Application Ref:	2025/0424			 Ribble Valley Borough Council www.ribblevalley.gov.uk
Date Inspected:	12/08/2025	Site Notice:	N/A	
Officer:	EP			
DELEGATED ITEM FILE REPORT:				
				APPROVAL

Development Description:	Proposed single-storey extension to rear and two-storey extension to side.
Site Address/Location:	58 Henthorn Road Clitheroe BB7 2NU

Proposed Floor Plans

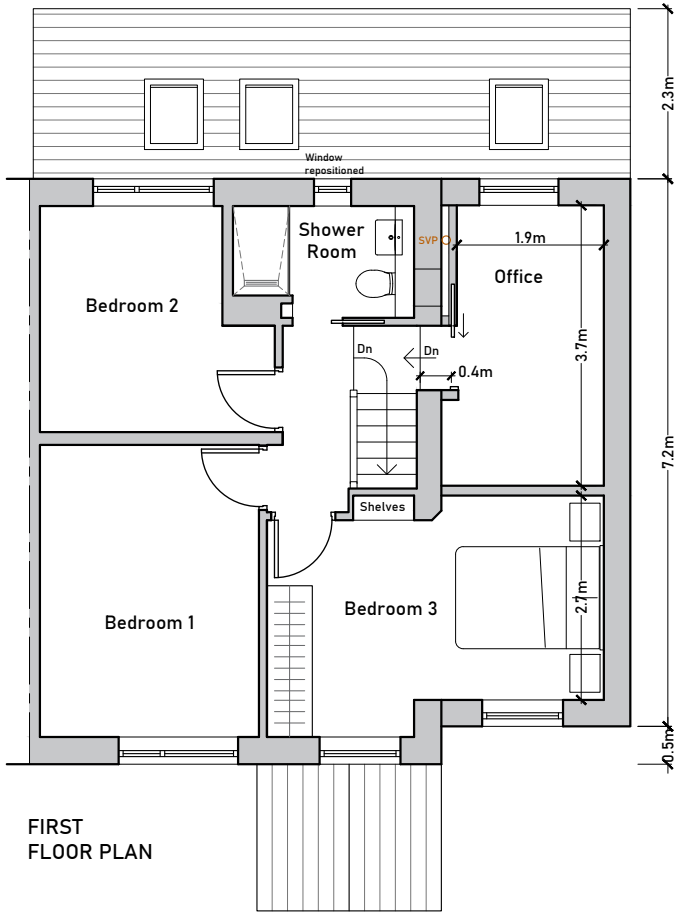
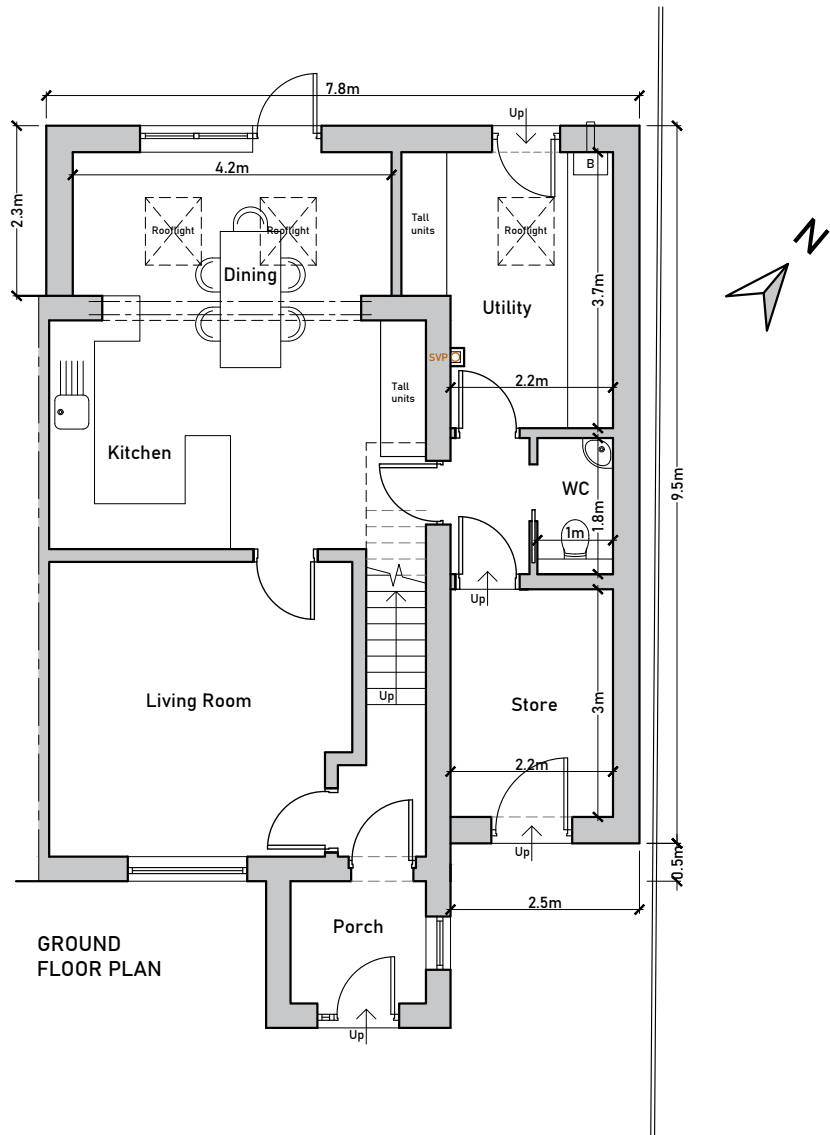
Consent is sought for the construction of a two storey side extension at the dwelling to accommodate a larger thirds bedroom and home office at first floor and a utility, wc and storeroom the ground floor. In addition, the proposal seeks consent for a single-story rear extension.

The proposed rear extension is modest in footprint, measuring just 2.3m from the rear elevation of the existing property. Given the modest footprint, the proposed extension would not result in any adverse impact in regard to loss of light. Something similar could be constructed utilising permitted development rights.

Drawing.
Proposed Elevations

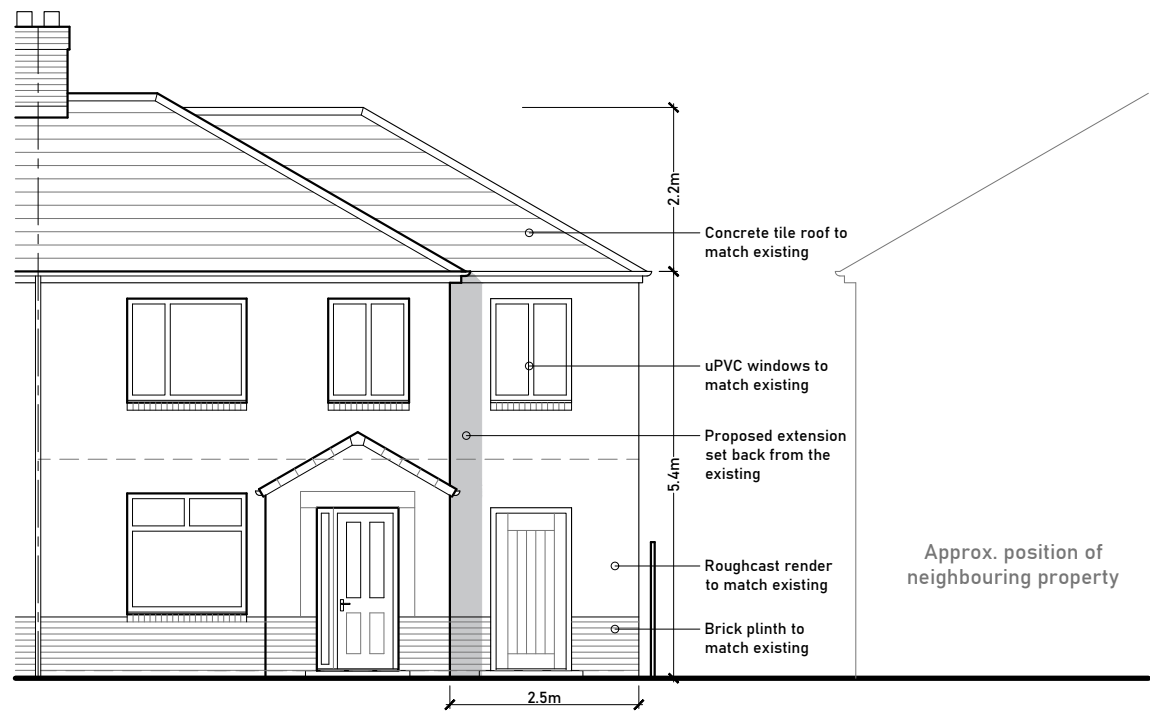
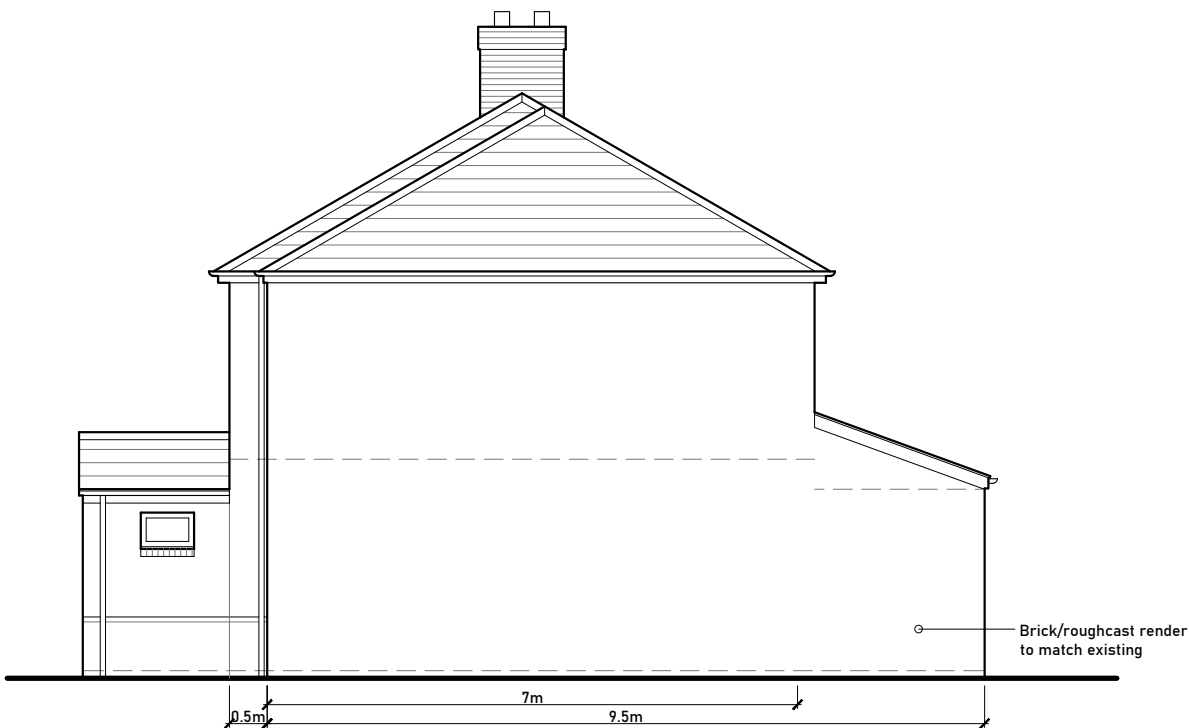
There is no new window openings proposed is the northeastern side elevation of the extension and as such no new opportunity for overlooking or loss of privacy is created in this respect.

There are new windows proposed in the rear elevation of the extension, however the nearest receptor to the rear is in excess of 30- metres from the development, with a distance of approximately 10 metres between the rear elevation of the extension and rear curtilage boundary. As such, there are no privacy concerns in this respect.

The proposed two-storey extension is readily visible from the public realm and whilst it comprises a significant footprint, it is set back from the principal elevation at the first floor and the roof pitch falls below that of the main roof. As such, it is considered it takes a subservient position to the host dwelling.

In respect to materials, the extension will be faced in pebbledash render with a facing brick plinth to match the existing dwelling. As such, the proposed development will integrate sufficiently into the street scene.
